**Rezoning Transportation Analysis**  
**Petition Number: Insert Zoning Petition #2021-215**  
*General Location Identifier: 03144101*

**From: Brandon Brezeale, PE**  
Brandon.Brezeale@charlottenc.gov  
704-432-5561

**Revision Log:**

Date	Description
01-24-2022	First Review (KP)
02-21-2022	Second Review (KP)

SCHEMATIC  
SITE PLAN

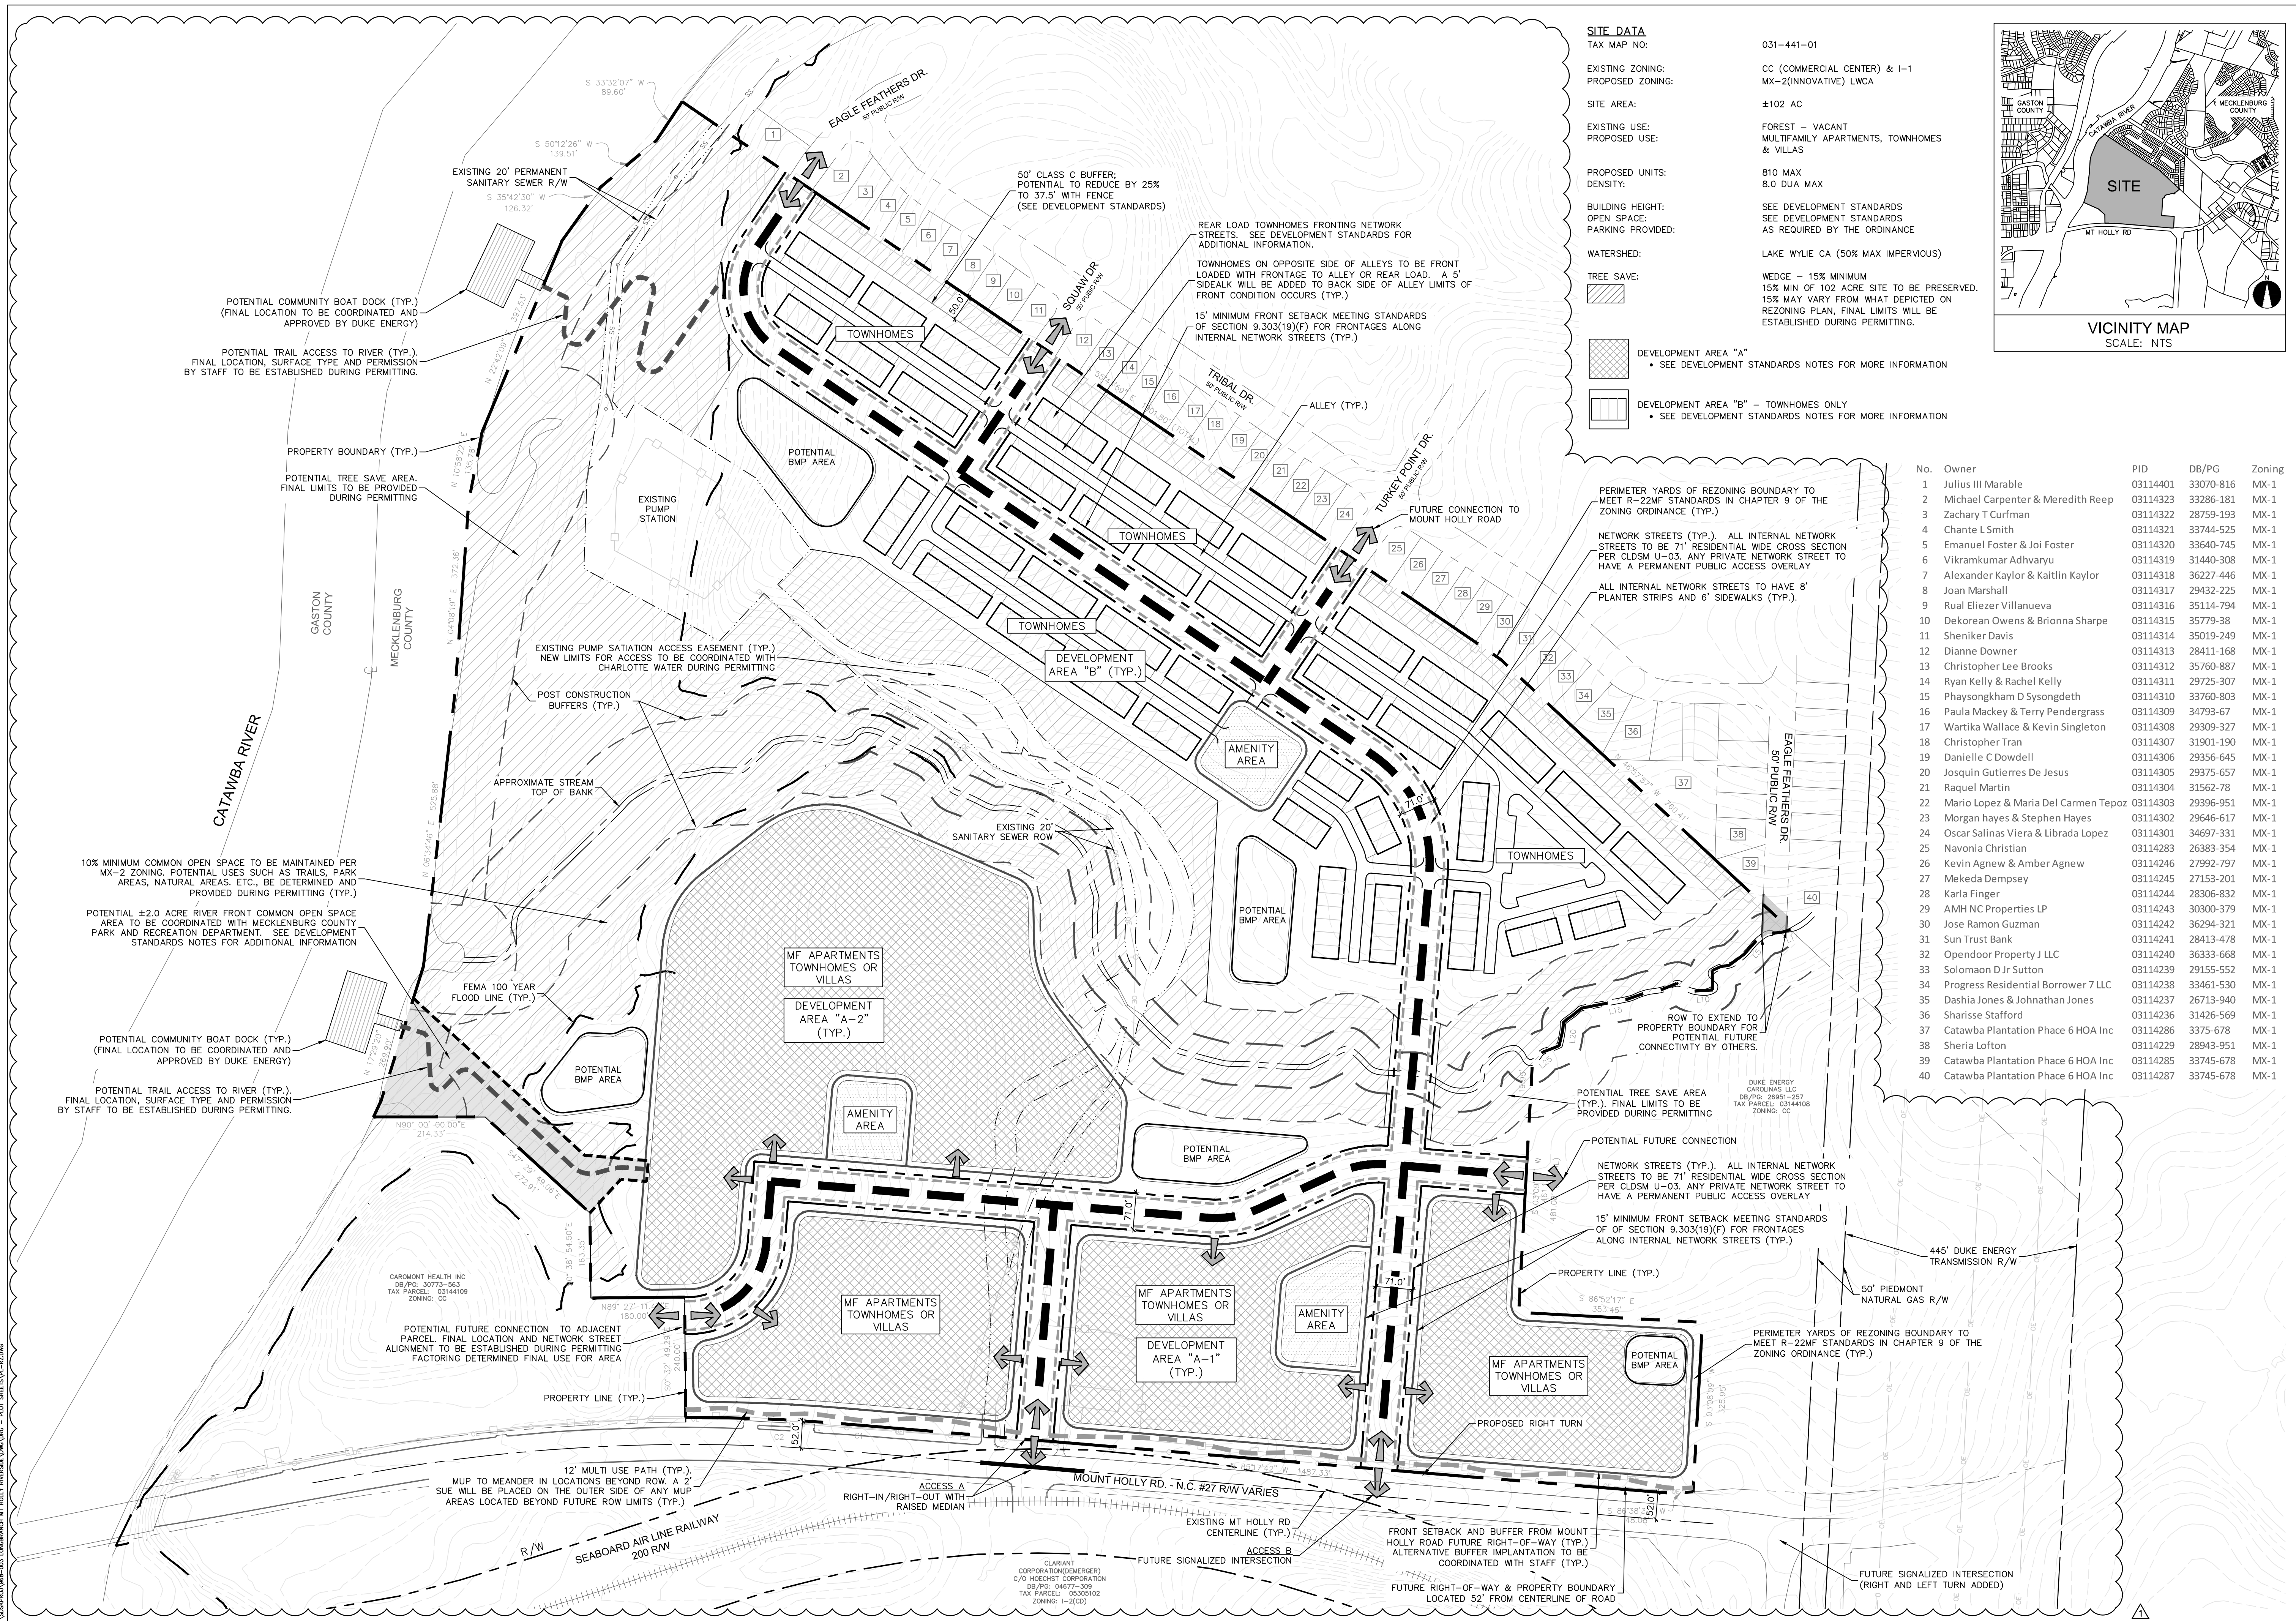
1. **Curb line:**

- a. **Mount Holly Road:** Curb line location shall be incorporated on the site plan pending approval of the TIS.

**Update to Comment as a Result of 02-14-2021 Site Plan:** The back of curb will be constructed 30-feet from the existing centerline.

The site plan shall label and dimension the curb and gutter from the existing centerline.

TECHNICAL  
 DATA SHEET

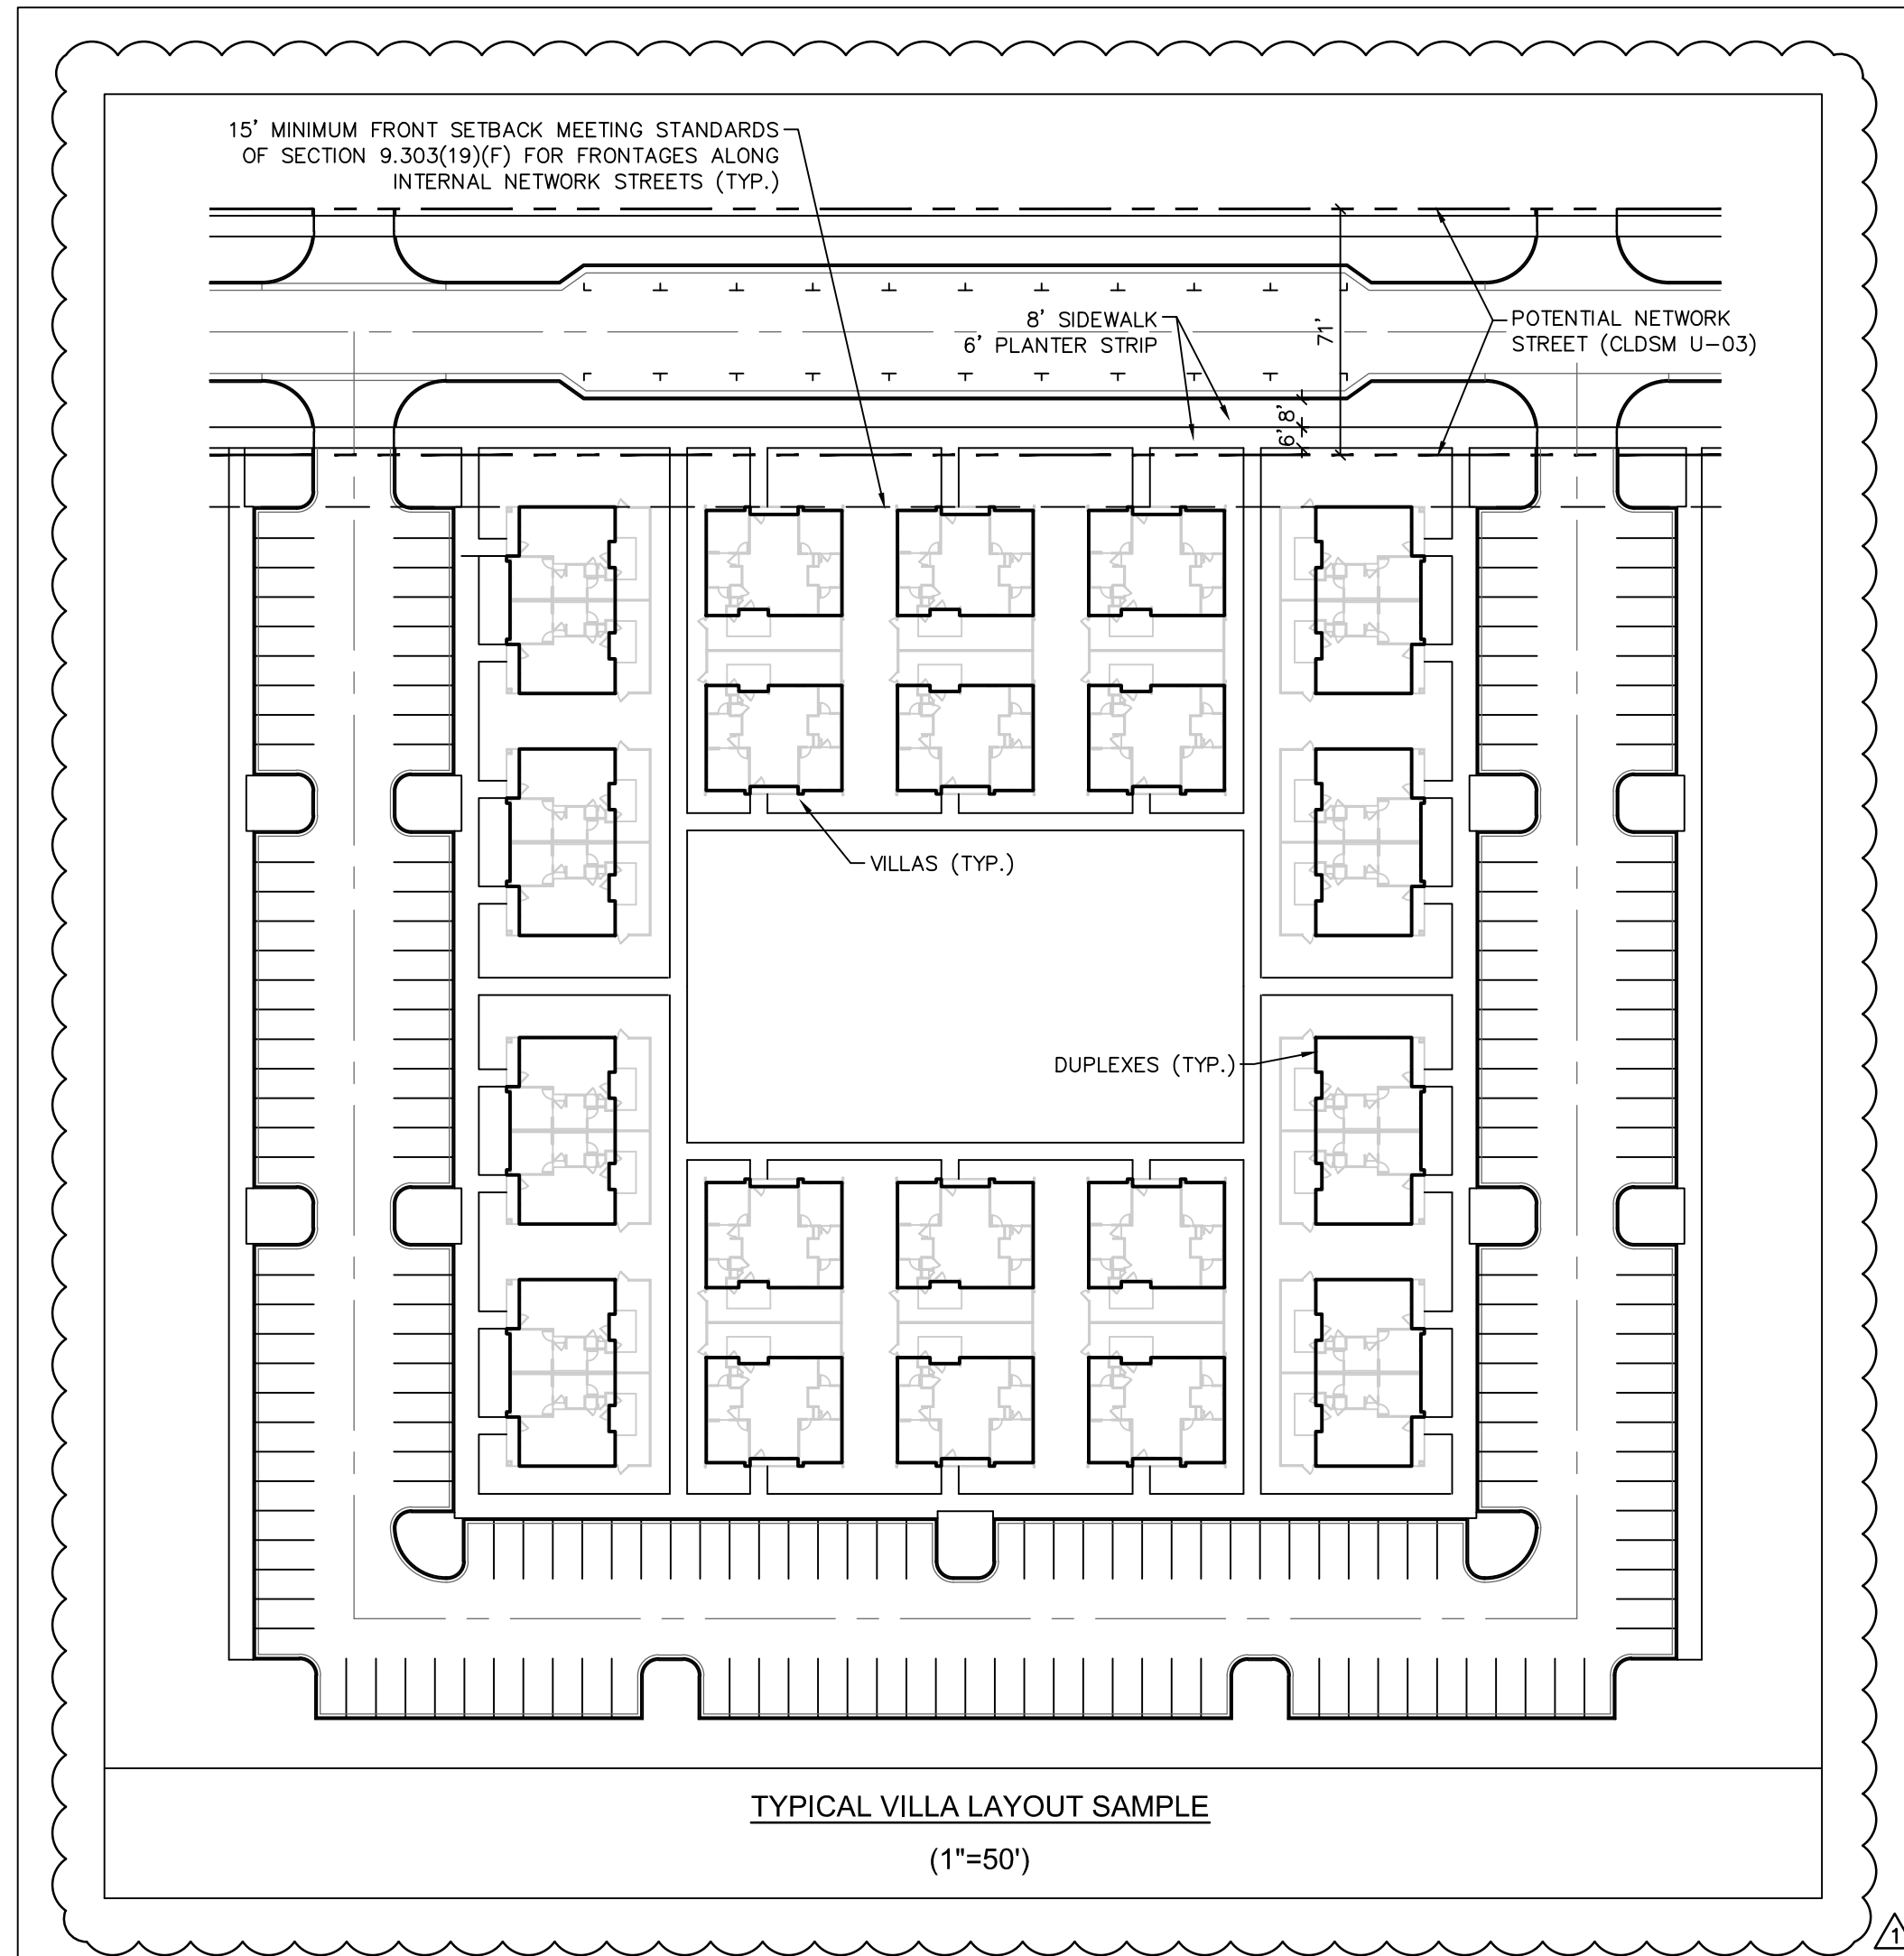
9. **Outstanding Comment from 01-24-2022:** Revise the conditional notes by removing notes 4.II.C and 4.II.E
